**From:** [Bill Booker](#)  
**To:** [A38 Derby Junctions](#)  
**Cc:** [Simon Cope \(simon.cope@eurogarages.com\)](#); [Tim Hancock](#); [Wilson, Andy](#); [Rob Green](#)  
**Subject:** A38 Derby Junctions Schemes  
**Date:** 26 March 2020 08:42:32

Following the postponement of the Hearing on 19<sup>th</sup> March we have, as requested, prepared an update for the Inspector in relation to the issues raised by Euro garages Ltd (EGL). This note has been prepared with input from Mr Tim Hancock and also Mr Simon Cope from EGL. The outstanding issues raised are summarised below under the following headings:

1. A52 access junction
2. A38 Ingress to the site
3. A38 Egress from the site
4. Advance Warning Signage

The
 ADL PROPOSED ACCESS AND EGRESS
 OFF HIGHWAYS ENGLAND SLIP LANE

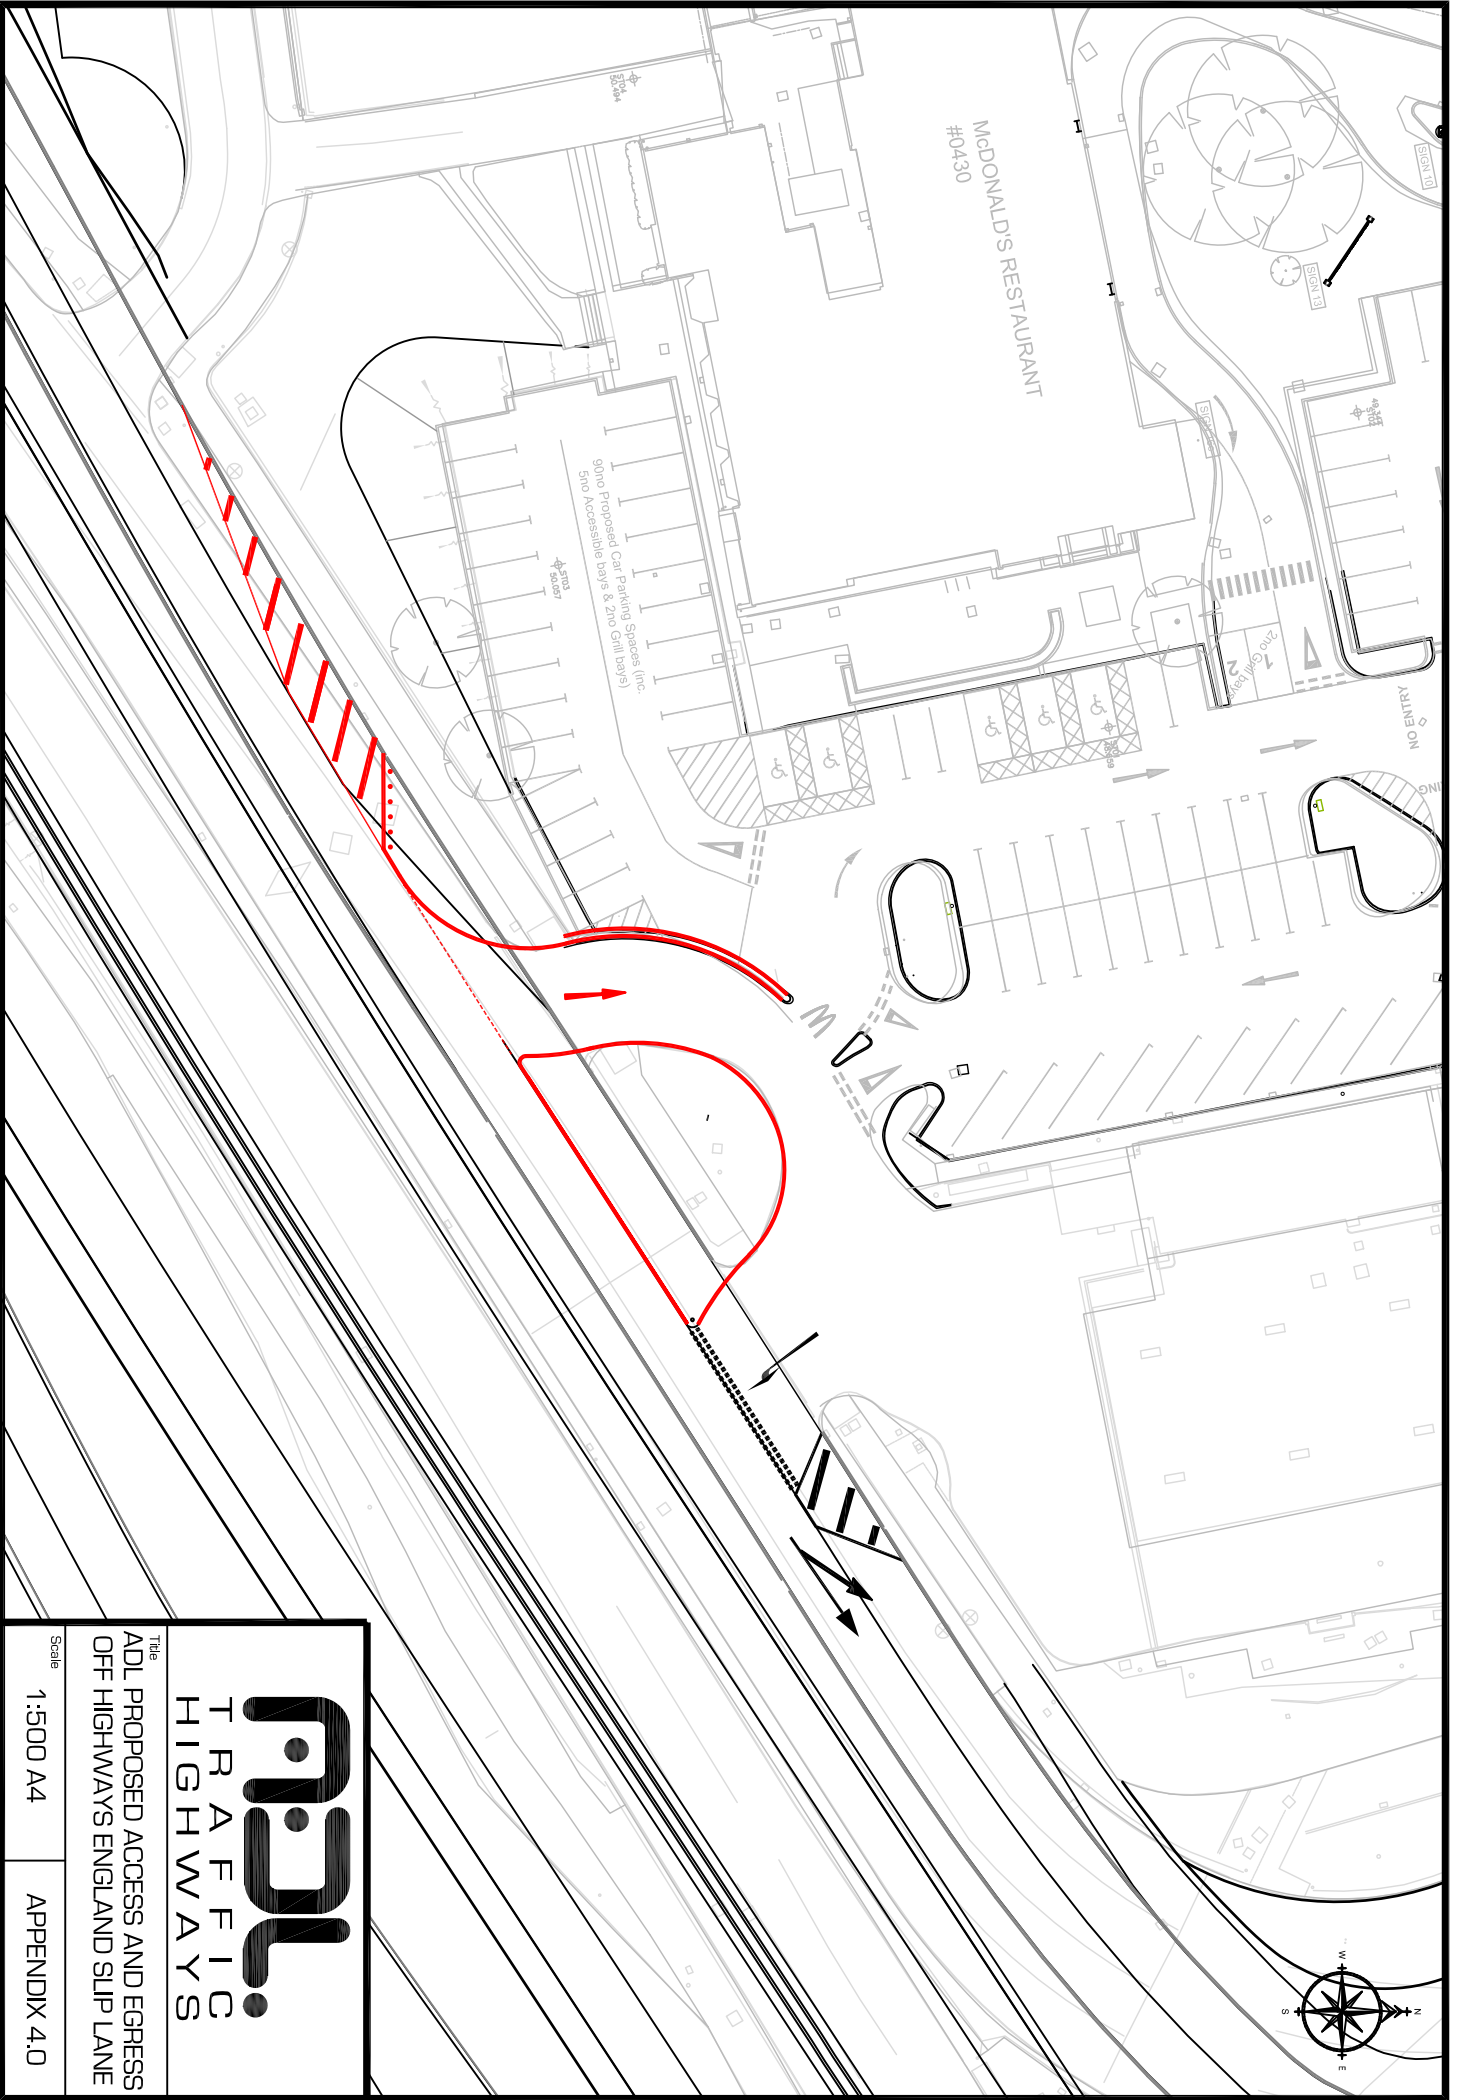
1. It is noted that the Applicant will not support retention of an ingress into the overall site from the A38. The in principle objection raised by Highways England to the ingress is noted.

2. The consequences of removal of the ingress from the A38 have not however been addressed because the right of way currently enjoyed by EGL will be frustrated. Additionally, the scheme includes locating additional parking spaces for McDonalds onto the right of way. **This point needs to be tidied up by the Applicant.**
